Monday, 1 December 2025

Re: Narrabri Lateral Pipeline (SSI-53307723) - Comments on the Environmental Impact Statement (EIS)

Whilst Council generally supports the project and acknowledges the ongoing economic benefit to the local area and the State, Council wishes to raise the following matters for consideration:

Figure 3.18 Kamilaroi Highway/Baan Baa Waste Facility access intersection upgrade – indicative concept

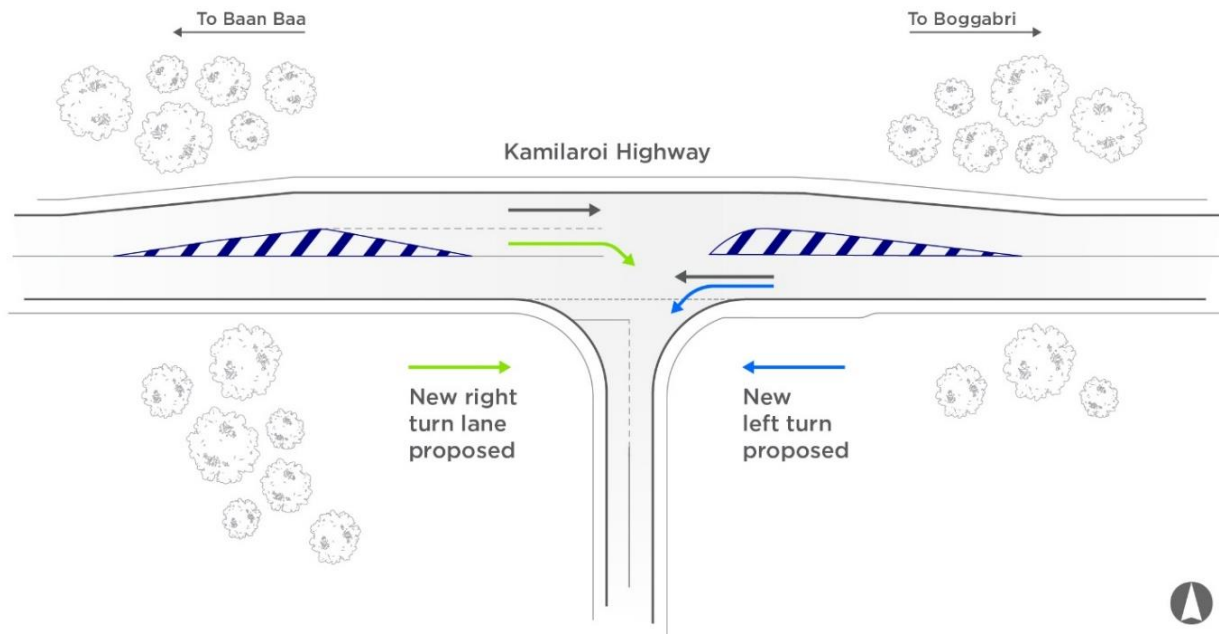
Council supports the development of a detailed trip and route planning which is proposed to be conducted during the construction planning process. And any future discussions around the proposed upgrade to the intersection of the Kamilaroi Highway and the Baan Baa compound access would be required. Additionally, any works on Council roads will require consultation with Narrabri Shire Council (NSC).
